**RE: Candelaria & 2nd Street NW Multi-Family
210 Candelaria Rd NW
Grading and Drainage Plans
Engineer's Stamp Date: 10/27/2025
Hydrology File: G14D103
Case # HYDR-2025-00389**

Based upon the information provided in your submittal received 8/26/2025, the Grading and Drainage Plans **are not** approved for Grading Permit, Building Permit, or SO19 Permit. The following comments need to be addressed for approval of the above referenced project:

CG-101

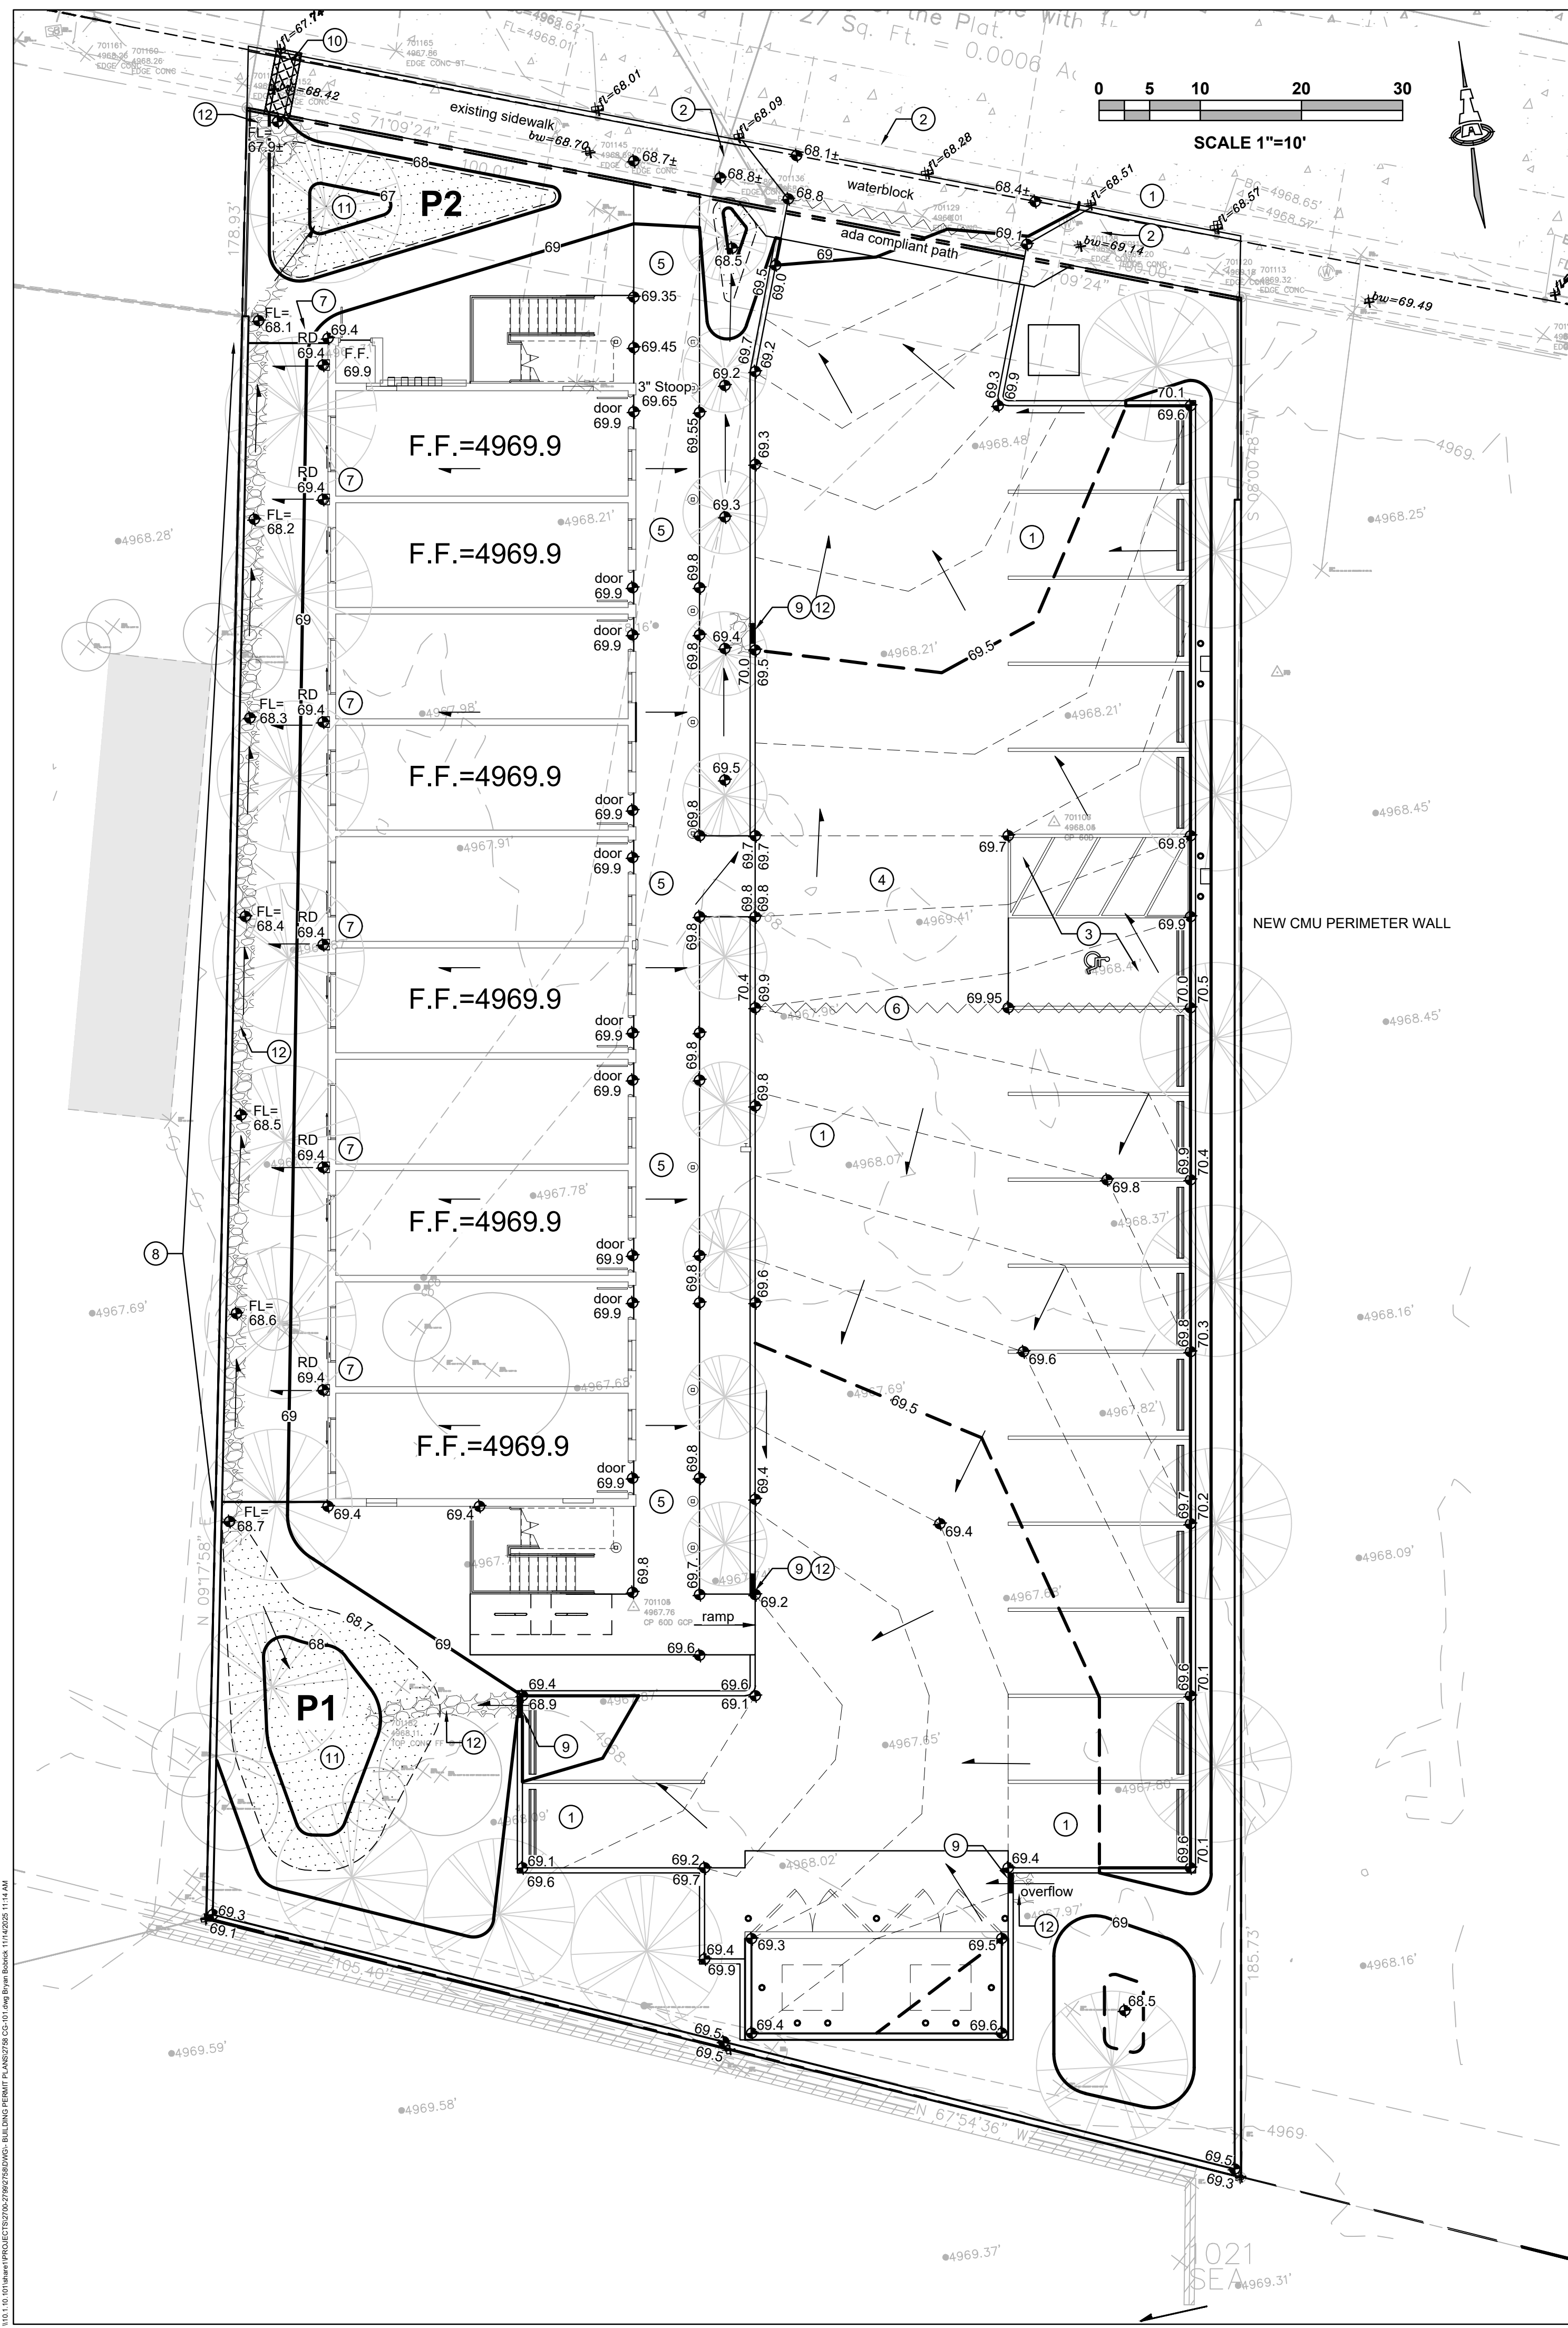
1. Please include in the Calculations Table the Existing Conditions .
2. Show the roof drain flow directions.
